City of Portland, Maine - Building or Use Permit Application

Permit No: 02-0193	Issue Date:	CBL: 076 A030001
-----------------------	-------------	---------------------

Past Use: trucking company	Proposed Use: Trucking Company,d.b.a Royal Lobster Approved ZBA on 2/21/02	Permit Fee: \$128.00	Cost of Work: \$15,000.00	CEO District: 3
Proposed Project Description: Fire escape per Zoning Board of Appeals		FIRE DEPT: <input checked="" type="checkbox"/> Approved <input type="checkbox"/> Denied	INSPECTION: Use Group: F Type: N/A 4/10/02	
		Signature: <i>[Signature]</i>	Signature: <i>[Signature]</i>

DATE	NOV 12 1900
BY	W. H. BECKER
CHECKED BY	W. H. BECKER
SCALE	AS SHOWN
PROJECT	ROYAL LOBSTER EGRESS-STAIR
NO.	19

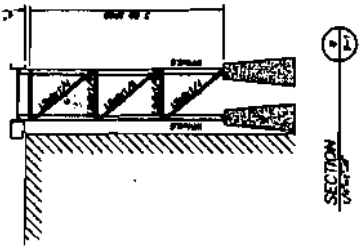
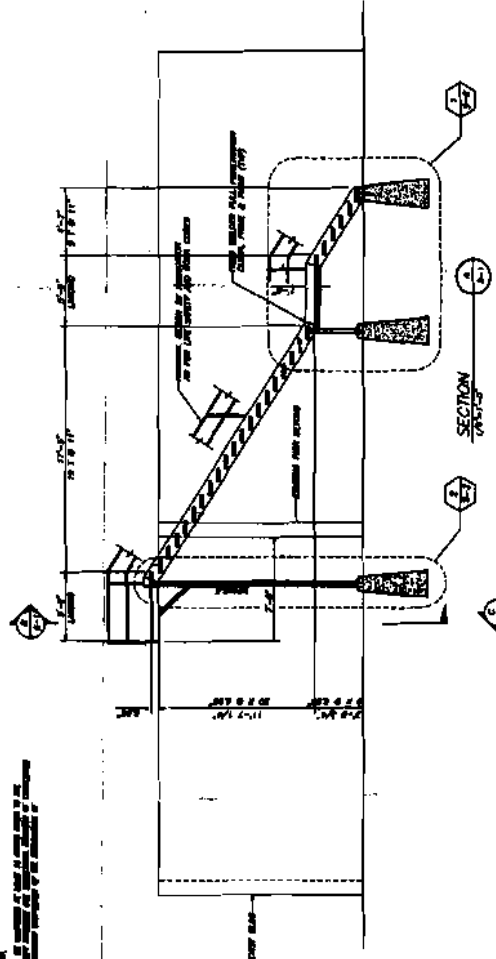
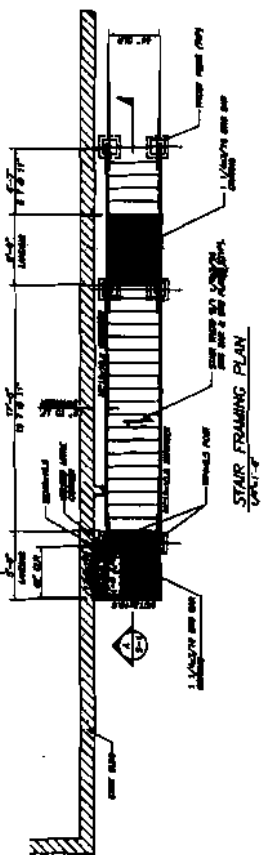
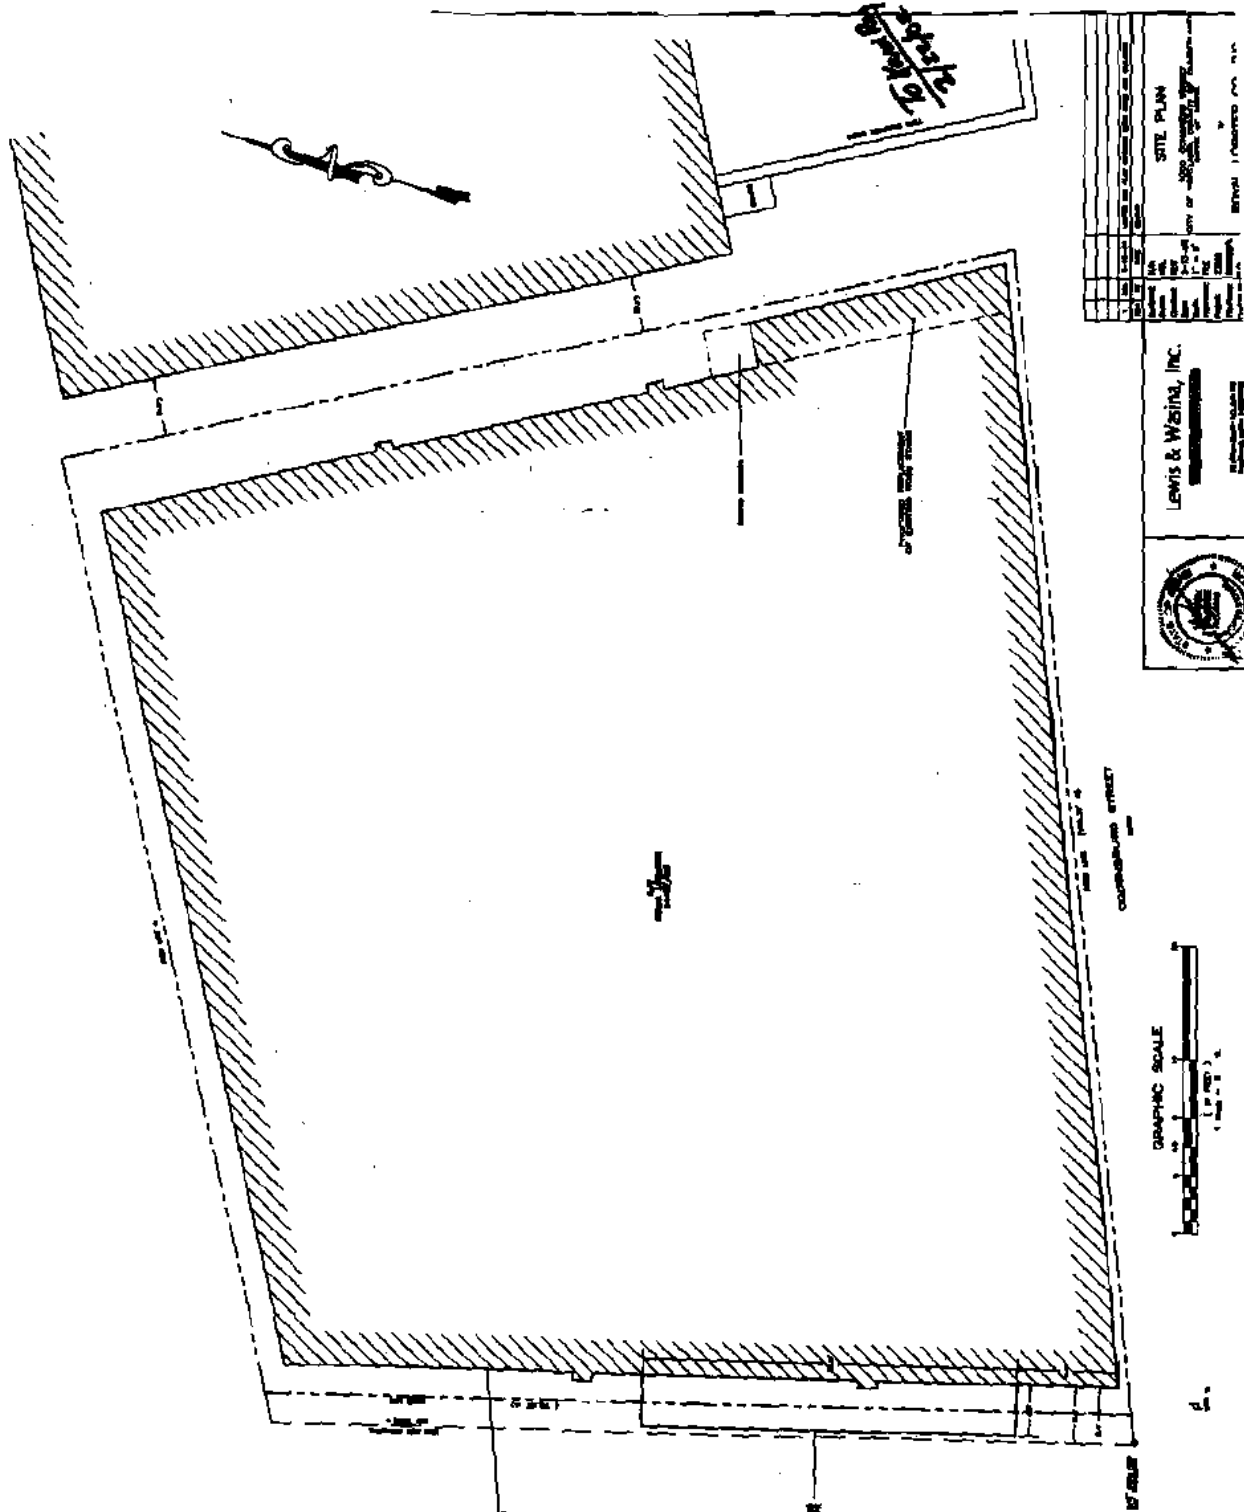
1) GUARDS ONLY 36⁴

LEFT MESSAGE MUST BE 42⁴
(PAUL BEKER)

Guards must be 42" w/ openings less than 21" (use group F)

Guards and handrails shall be installed in accordance with NFPA 101
